# CITY OF ALBUQUERQUE

July 9, 2024

**RE: Event Center  
1611 Airtech Ct. SE  
Grading and Drainage Plans  
Engineer's Stamp Date:06/20/24  
Hydrology File: N15D017**

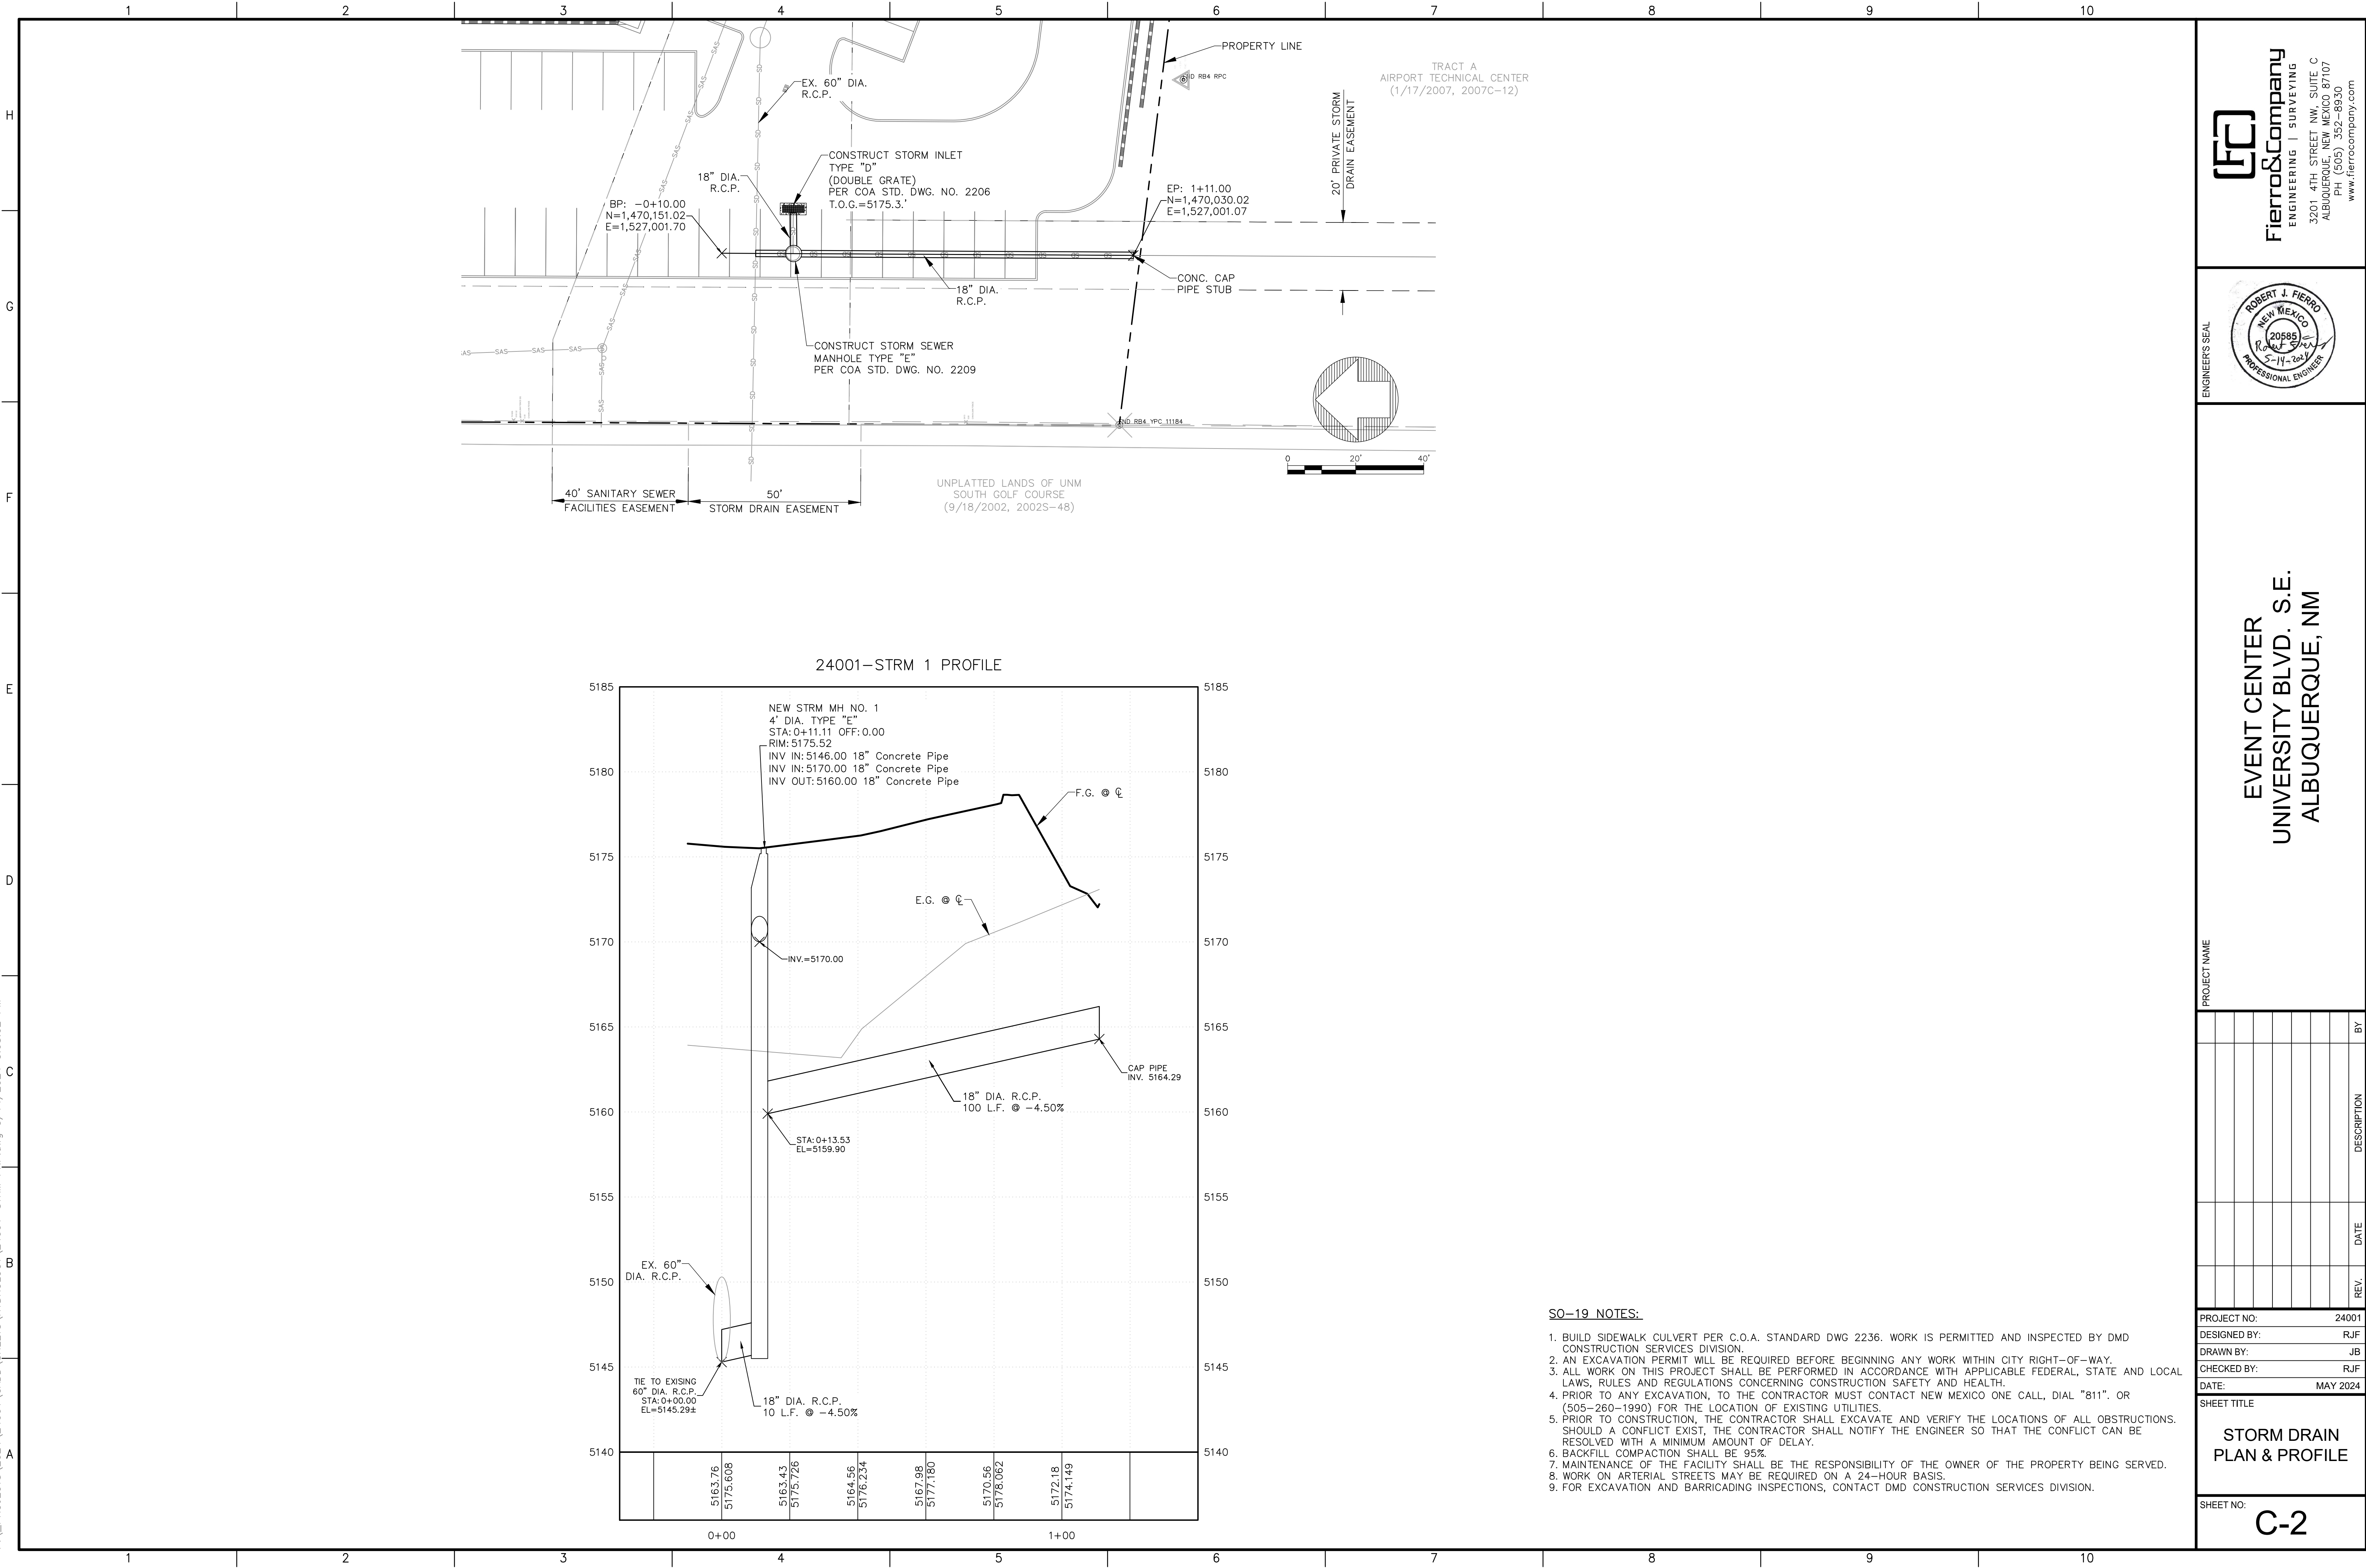
2. I would highly recommend that the existing manhole rim elevation be topo'd along with the inverts of the 60-in storm sewer.

3. Also looking at the as-builts and the amount of fill that is being brought in on top of the existing 60-inch RCP Class III. This will have to be replaced with a 60-inch RCP Class IV due the cover and original installation. Please specify the limits of this existing storm sewer that will need to be changed to Class IV.
4. As discussed with the City Engineer, Shahab Biazar, please provide written proof from a structural engineer that the retaining walls as designed will be buildable and will not create safety issues with the adjacent property. There is limit space for compaction.

STORM INLET TYPE D (DOUBLE GRATE)

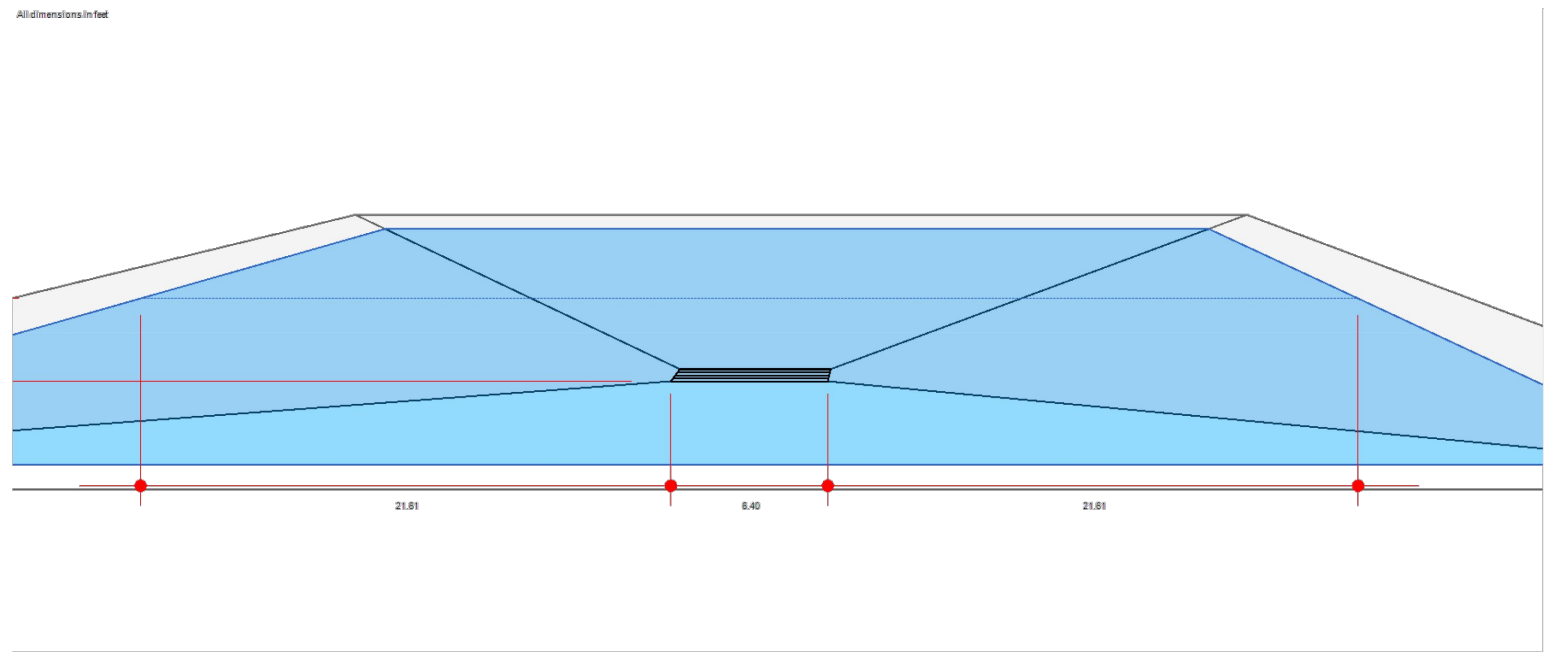
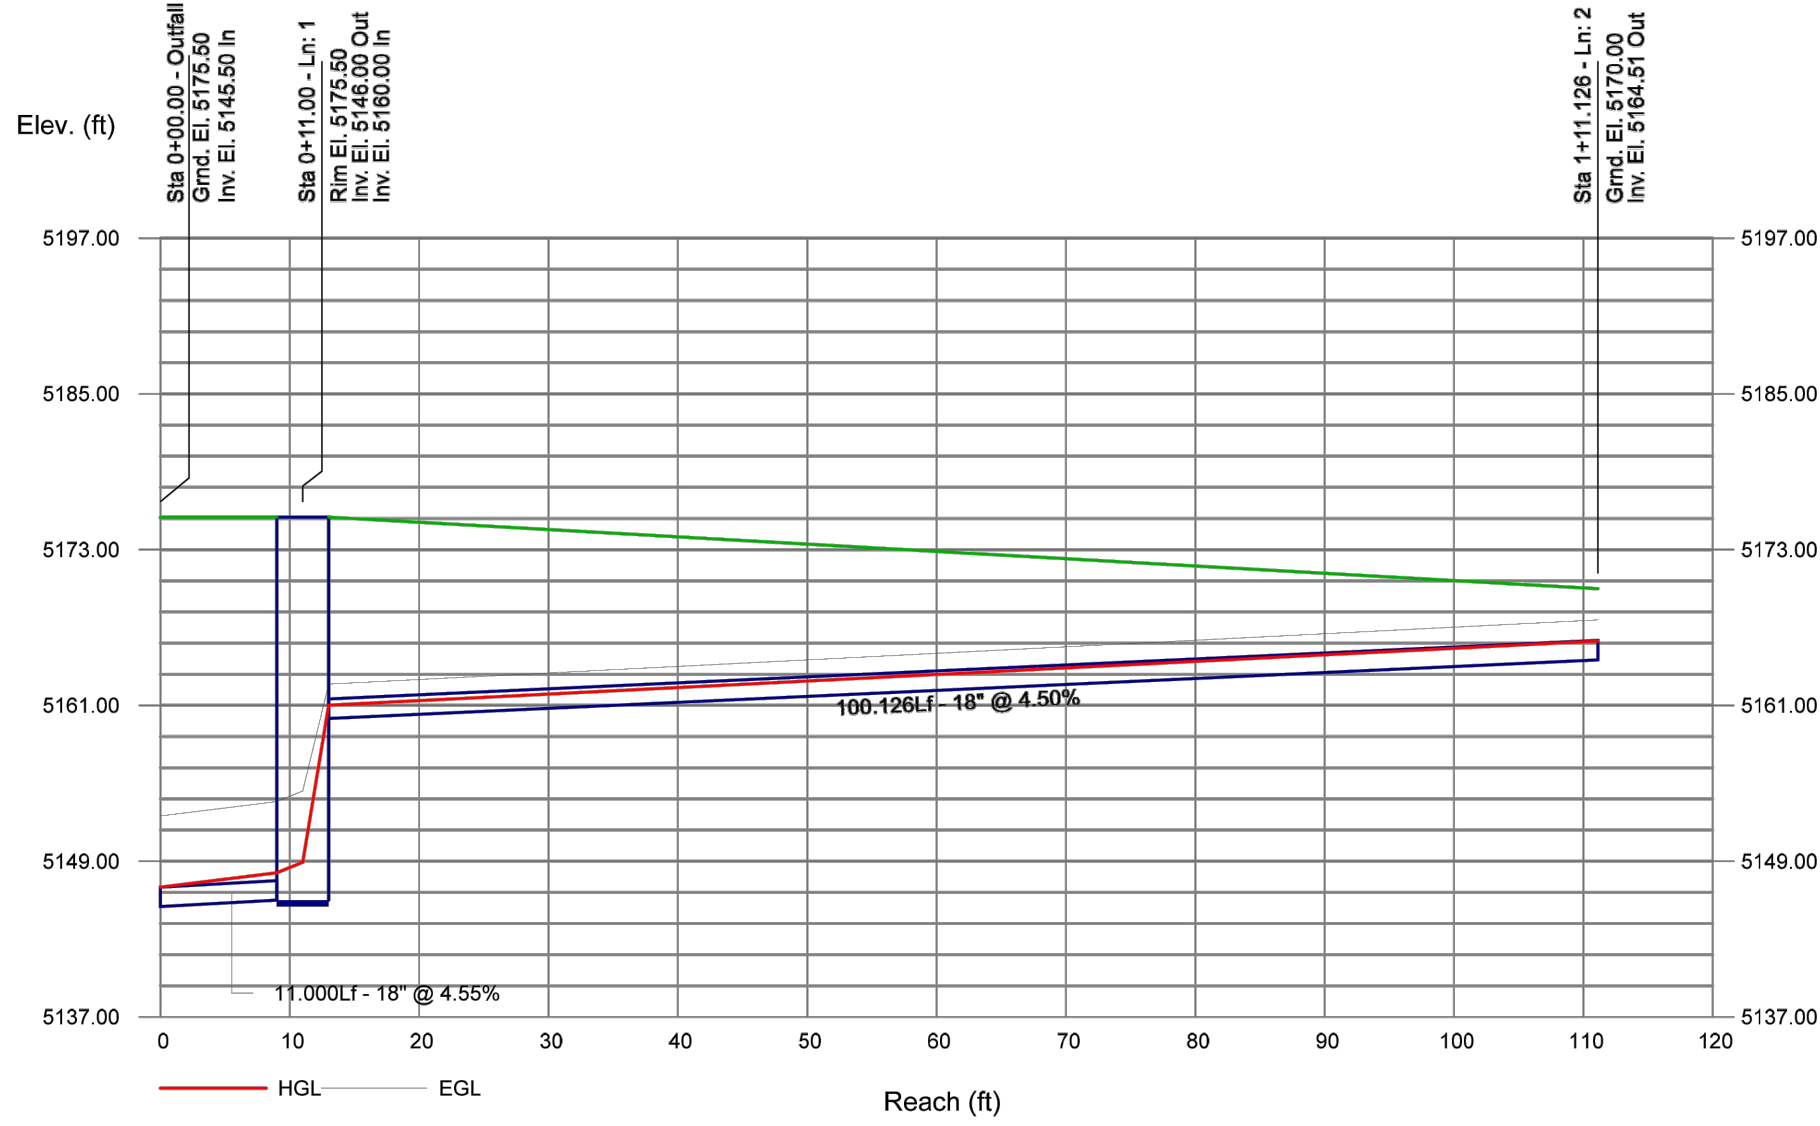
1. The constructability with the Type D inlet along with the 18-in storm drain connecting to the existing 60-in pipe. This should a manhole with a grate top?? Please clarify the design.
